RFI

RFI #: 112
Date: 5/4/2012
Job: EB-02 Keller Springs Lofts
Phone: 877-777-5115

Subject: Moving Piers at Stair Tower #5

Drawing: S2.14P
Cost Impact: None

SHEET NUMBER
S2.14P

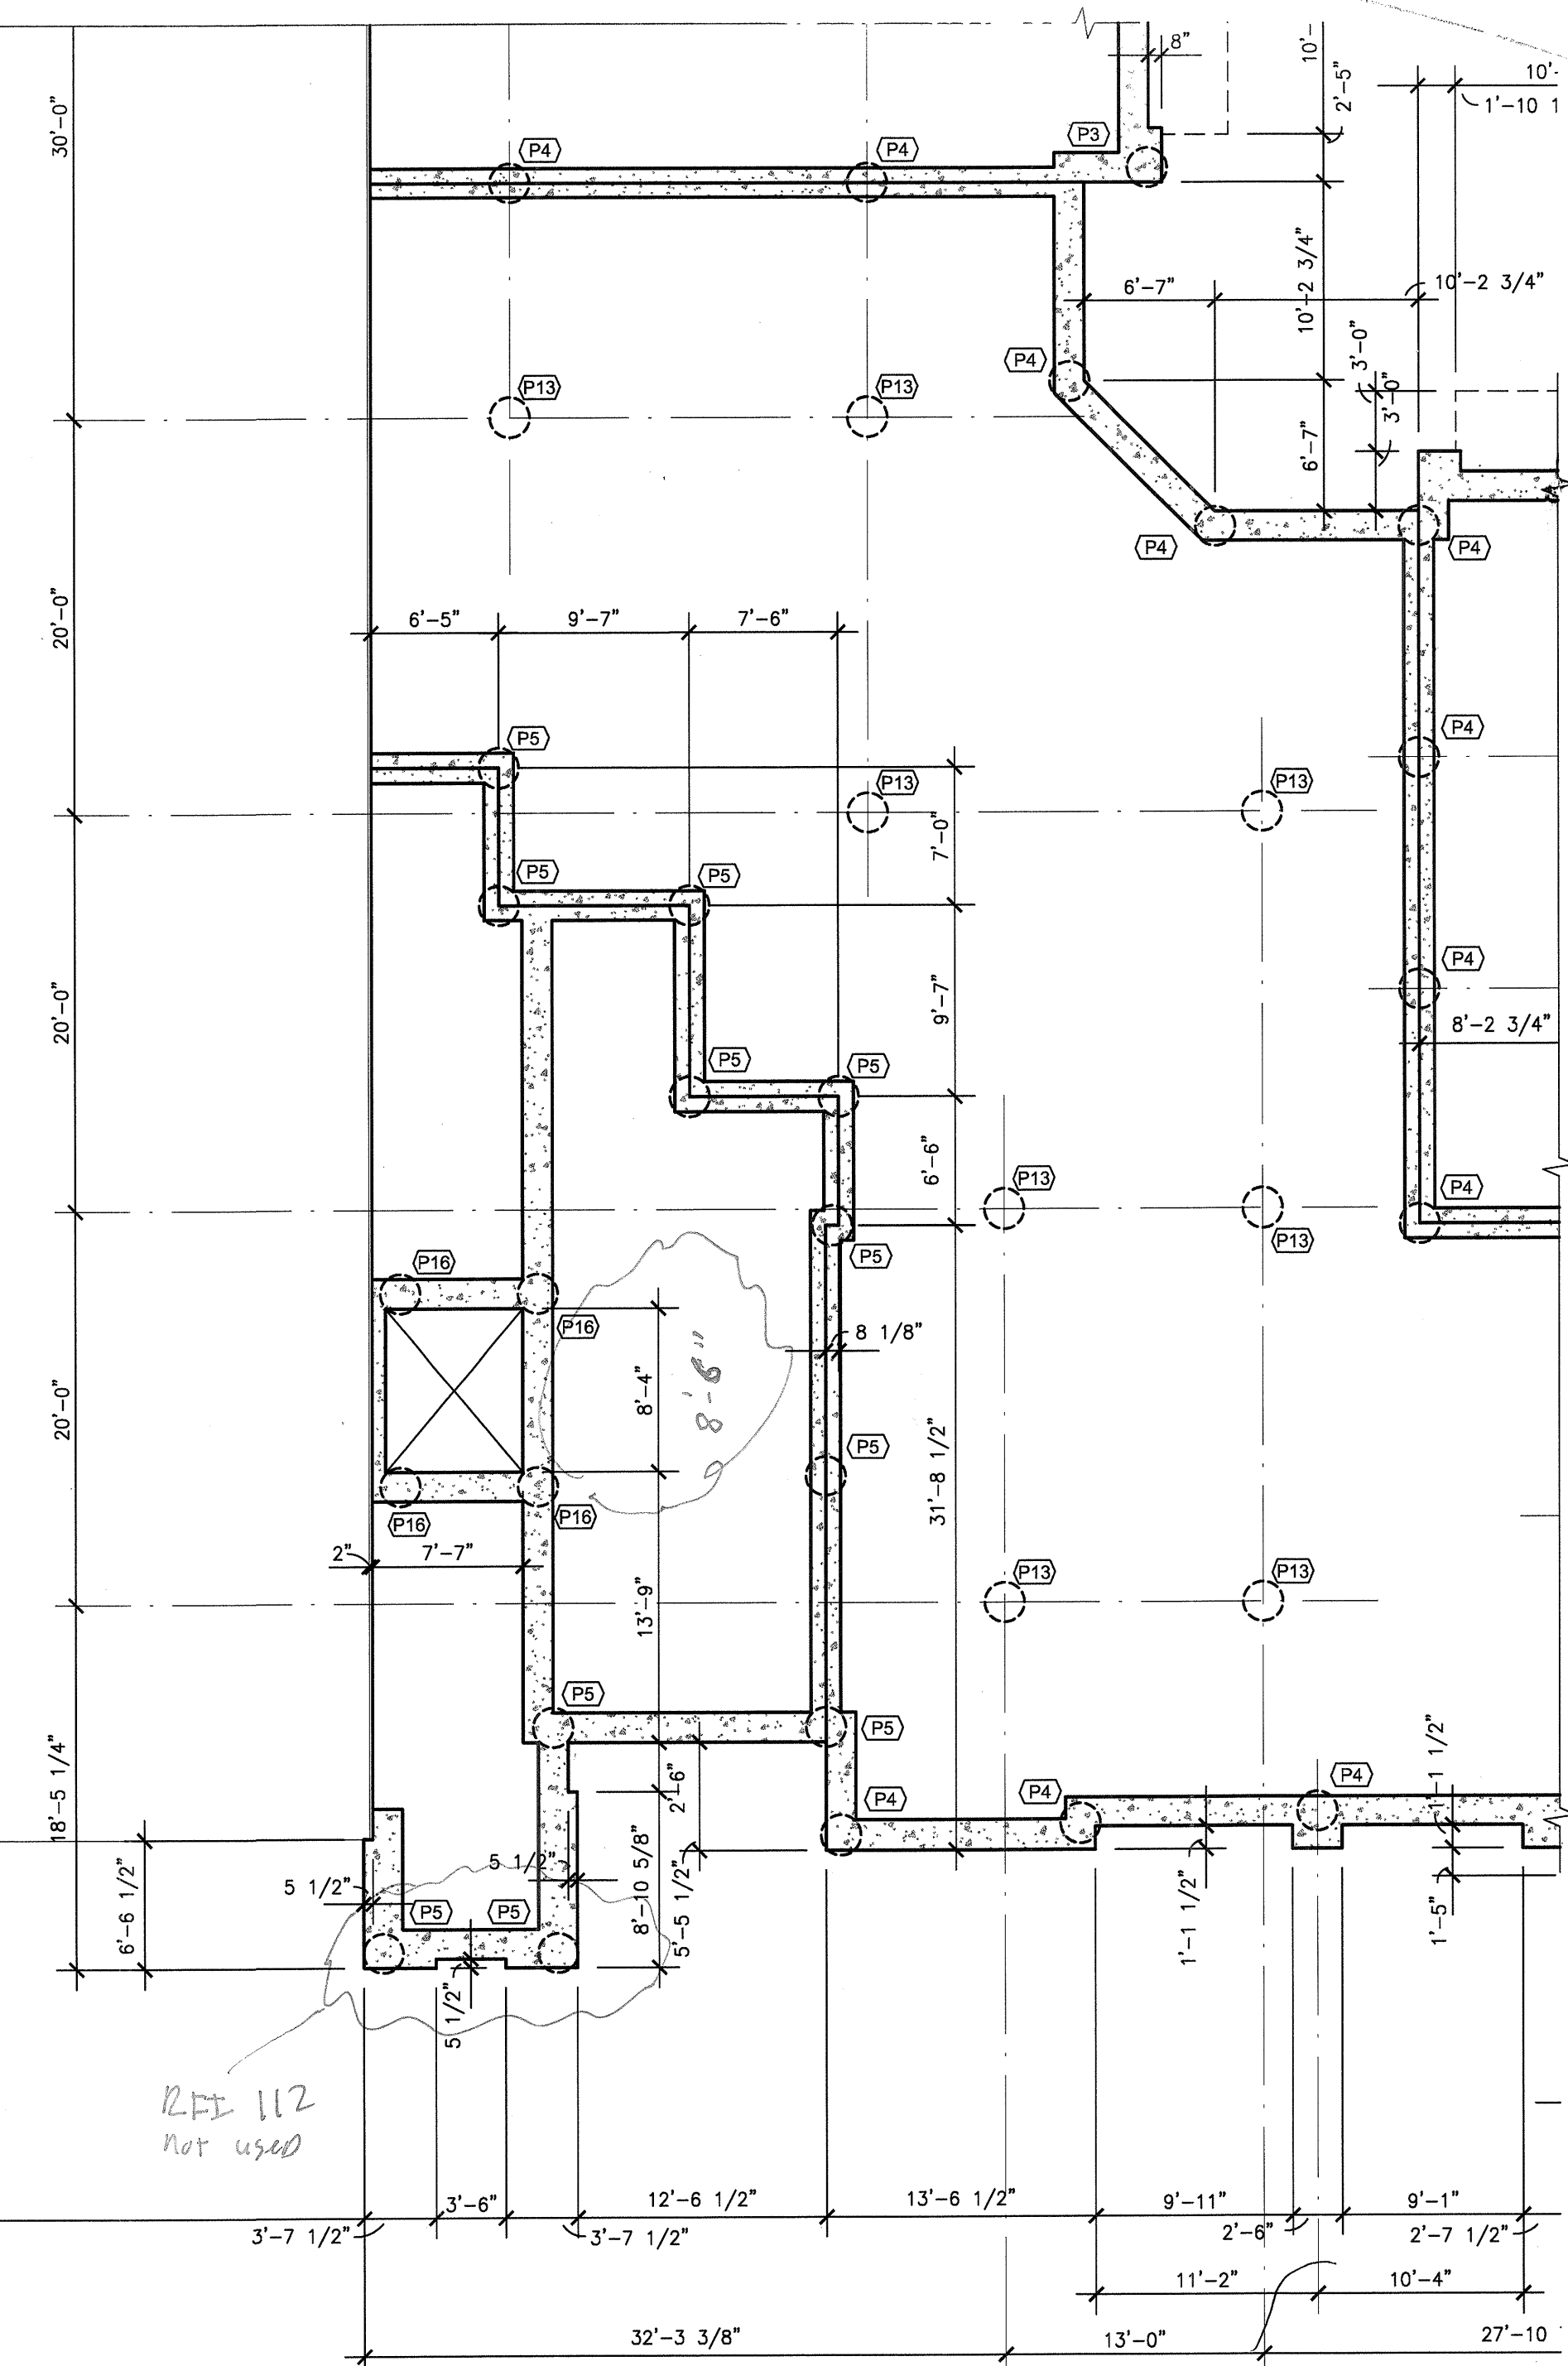
Request: Date Required: 5/9/2012
Please confirm that we can move the P5 piers at the south end of Stair Tower 5 two feet to the north. This is to accommodate underground conduits already in place.
Requested by: David Miller
Embrey Builders LLC

Response:
Confirming conversation in the field, piers may be located as indicated above to avoid conflicts with underground conduits.
R. Trent Perkins, P.E. May 28, 2012
Parkin-Perkins-Olsen Consulting Engineering, Inc.
